KITTITAS COUNTY COMMUNITY DEVELOPMENT SERVICES

Subject: Slater Parcel Combination (CB-20-00009)

Kittitas County CDS has performed an initial review of the application materials submitted on October 9, 2020 and additional information provided on October 27, 2020, for a parcel combination of 36 tax parcels into 5 new tax parcels. The parcels provided by the applicant are: 089236, 099236, 131536, 20812, 20813, 20814, 20815, 20816, 20817, 20818, 20819, 20820, 20821, 20822, 20823, 20824, 20825, 20826, 20827, 20828, 20829, 20830, 20831, 291536, 329236, 463337, 473337, 483337, 493337, 523337, 533337, 543337, 586936, 599236, 639236, 692336, and 929236. There are 37 tax parcel numbers that have been included in the additional information provided by the applicant, rather than the stated 36. After our conversation it was determined there was a mistake as the proposal should include 12 new tax parcels after the combination, not the requested 5 as stated in the narrative and on the provided site map. As of October 27, 2020, this application has been **determined to be incomplete**. In order for the County to continue processing this application, additional information and clarification is re

PROPOSED Tax Lot CONFIGURATION

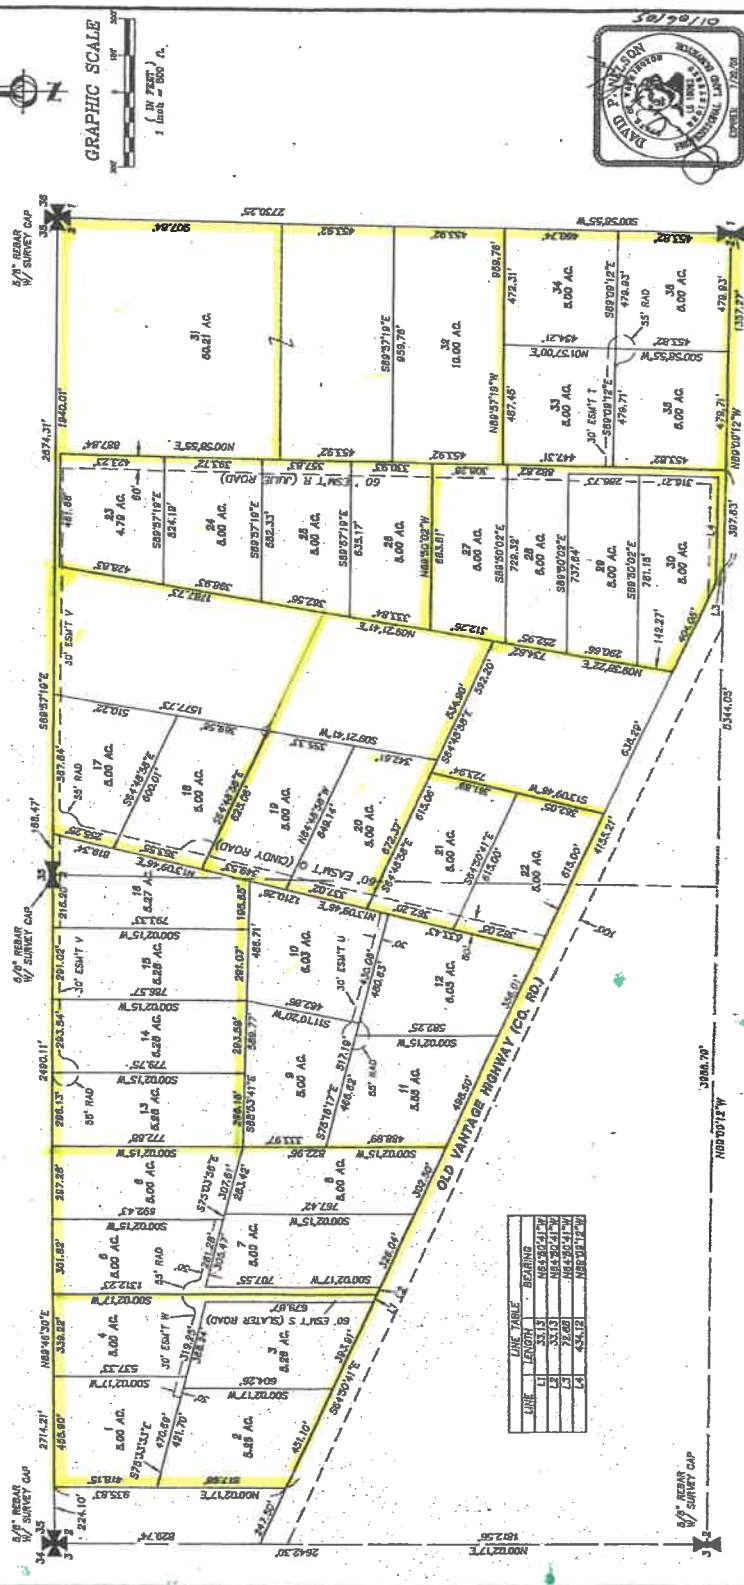
- Provide the tax parcel numbers included in the Parcel Combination.
- Provide an updated detailed site plan that shows in full all existing 36 tax parcels, existing lot lines and the proposed new lot lines, and all existing structures including the setbacks from the existing structures to the proposed lot lines.
- Prior to final approval, a tax receipt showing the full-year taxes are paid in full must be provided.
